**From:** Nicholas Hon  
**Sent:** Monday, 1 May 2017 9:09 AM  
**To:** Amy Robertson  
**Cc:** Natasha Harras  
**Subject:** RE: 96 (1A) Modification to Proposed Dangerous Goods Facility (SSD 7491 MOD 1)

- *SSD 7491: Oakdale Central – S.96 Application to Modify Condition B6 concerning Maximum Permissible GFA on the Site (letter from Goodman, dated 28 March 2017); and*
- *4 drawings prepared by SBA Architects, dated 1 December 2016: OAK 3 DA 01 (X), OAK 3 DA02 (W), OAK 3 DA 03(H) and OAK 3 DA 10(W).*

*In essence, the proposed modification is to increase the total Gross Floor Area (GFA) of Warehouse 3B from 36,365 to 37,454 m<sup>2</sup>, primarily for warehousing space. Warehouse 3B is designed for storage of non-dangerous goods and dangerous goods (limited to the quantities listed in Condition B7 of the current consent).*

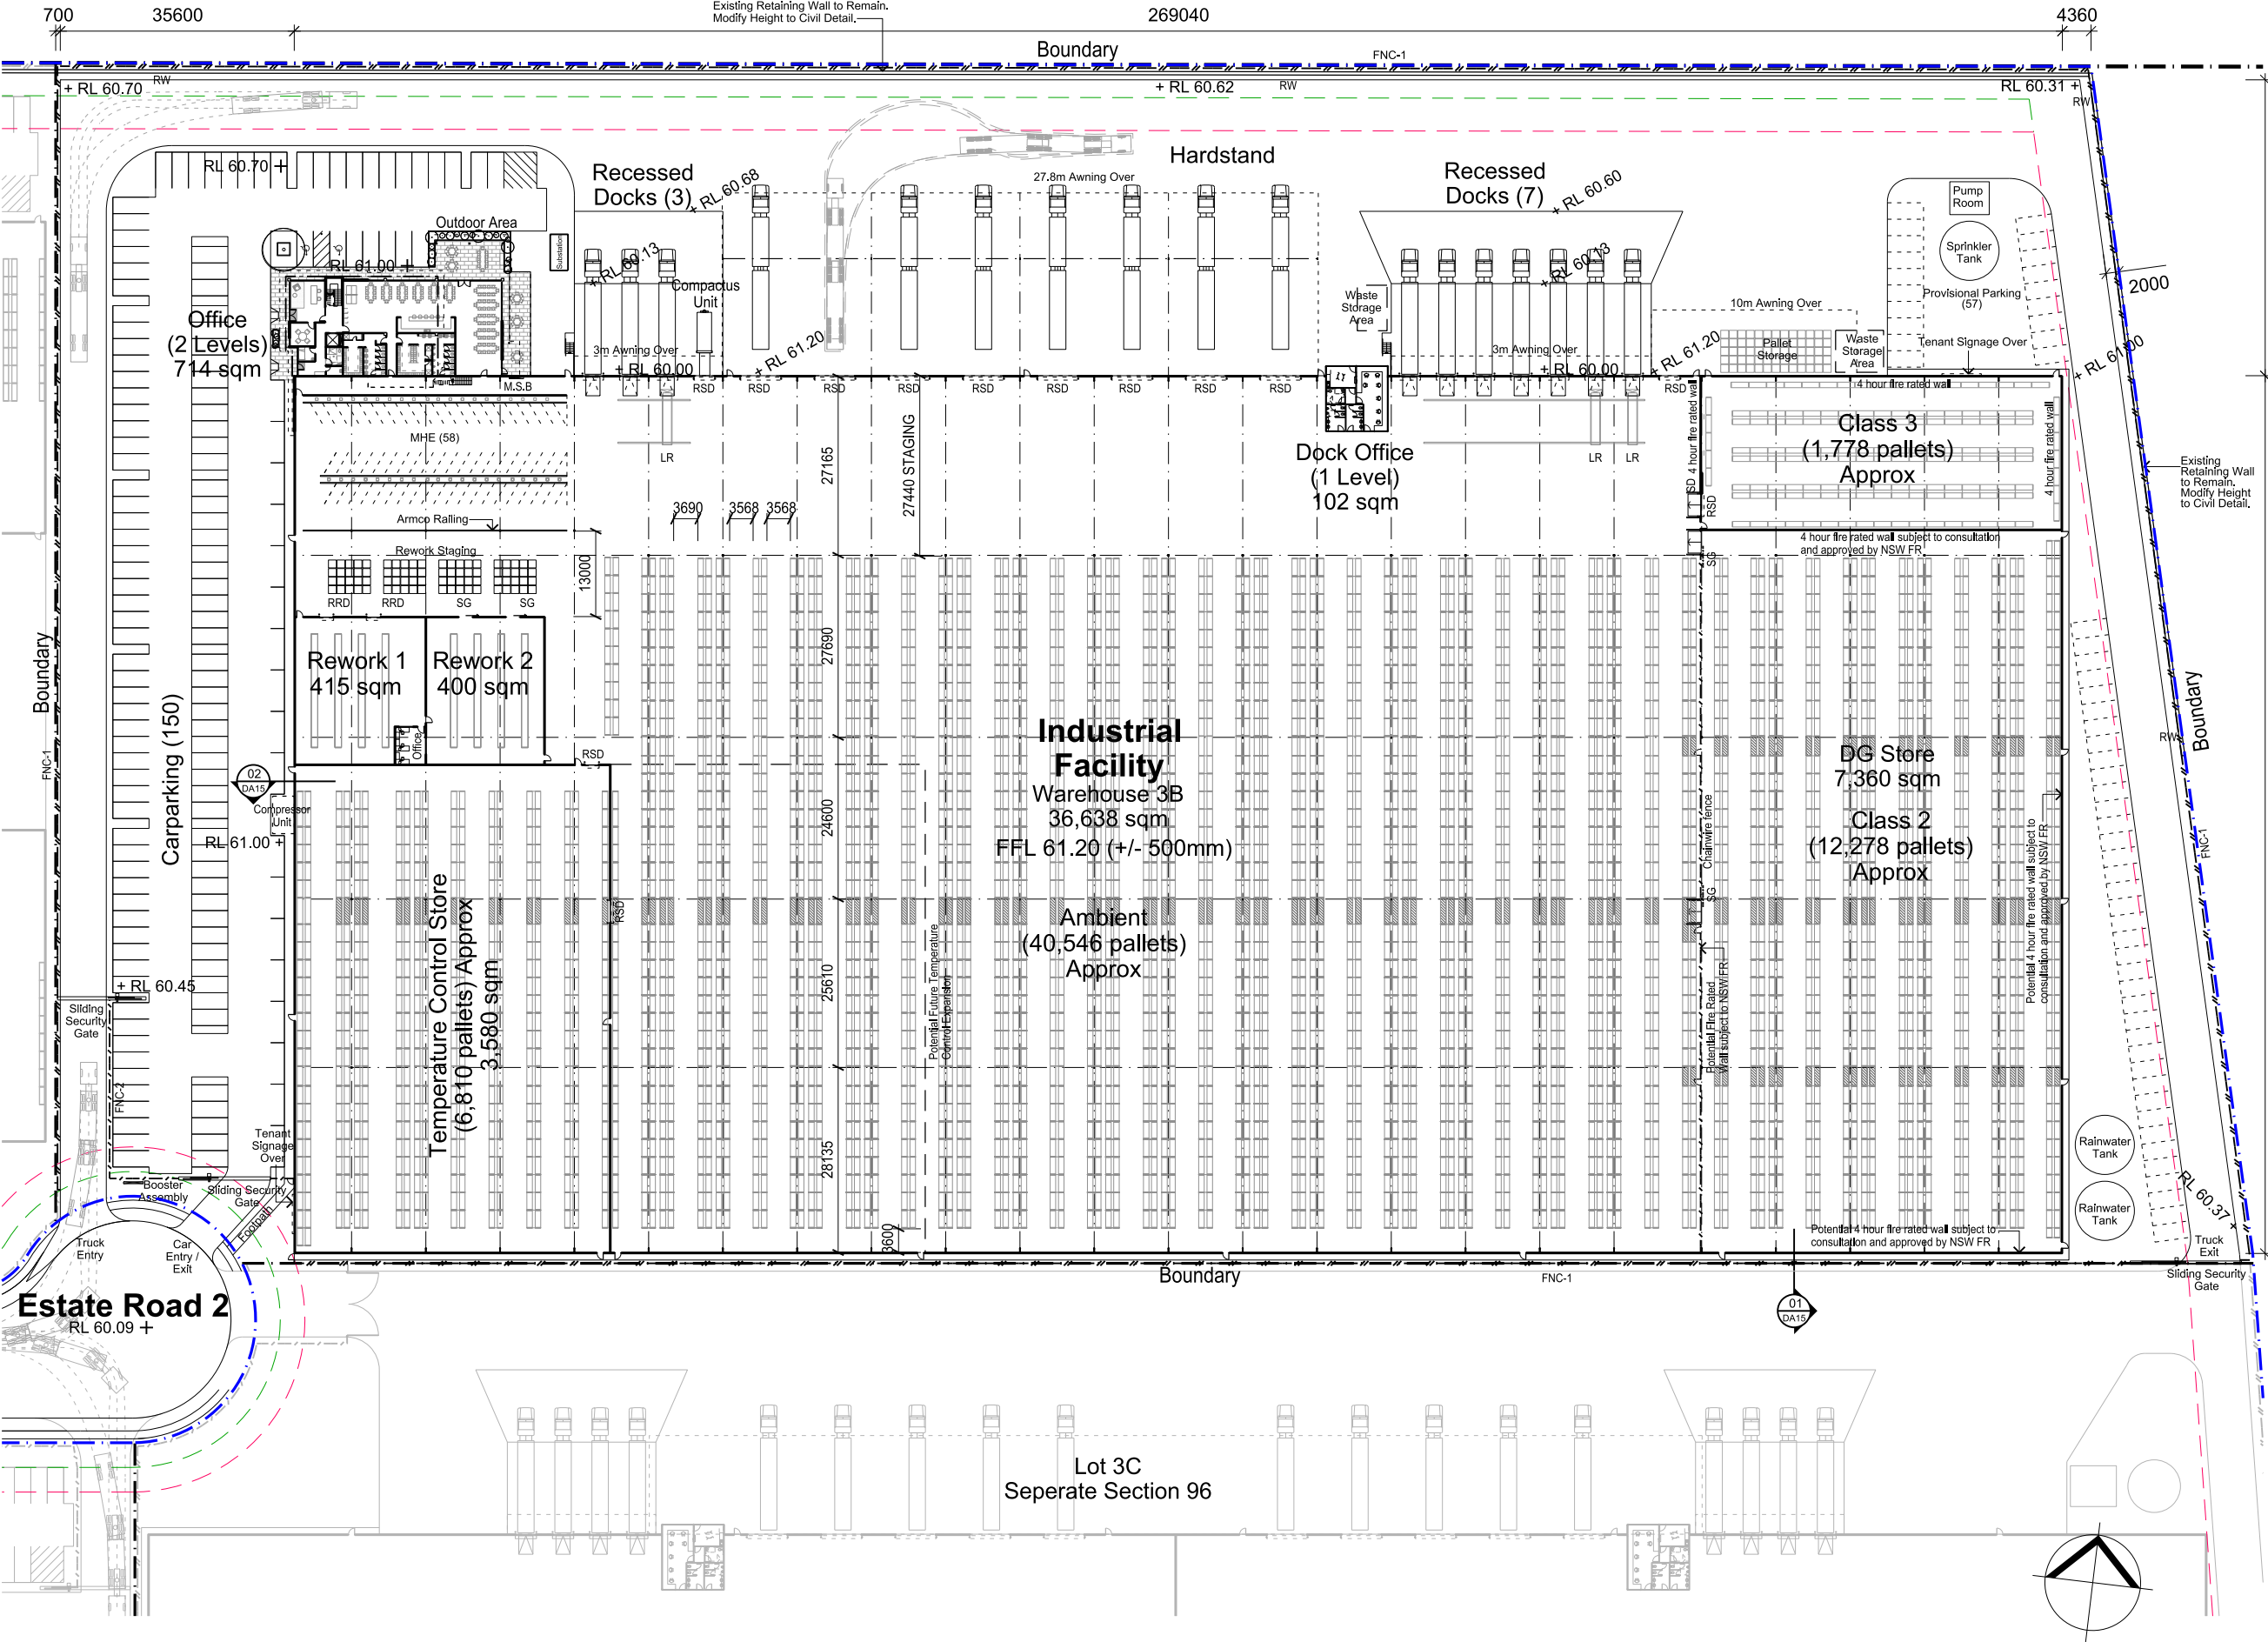
- *The Site Plan / Floor Plan [drawing OAK 3 DA 10(W)] indicates 1 sprinkler (firewater) tank will be installed north of the dangerous goods storage area.*

- *Figure 3-5 of the Final Hazard Analysis (FHA, dated 18 October 2016), submitted as per Condition C28(b) of the current consent and currently being reviewed by the Department, indicates 2 sprinkler tanks will be installed at the same location.*

***Two storage tanks are proposed to be provided as per Fig 3-5 of the FHA (the certifier does not require the additional tank to be included in the approval plans).***
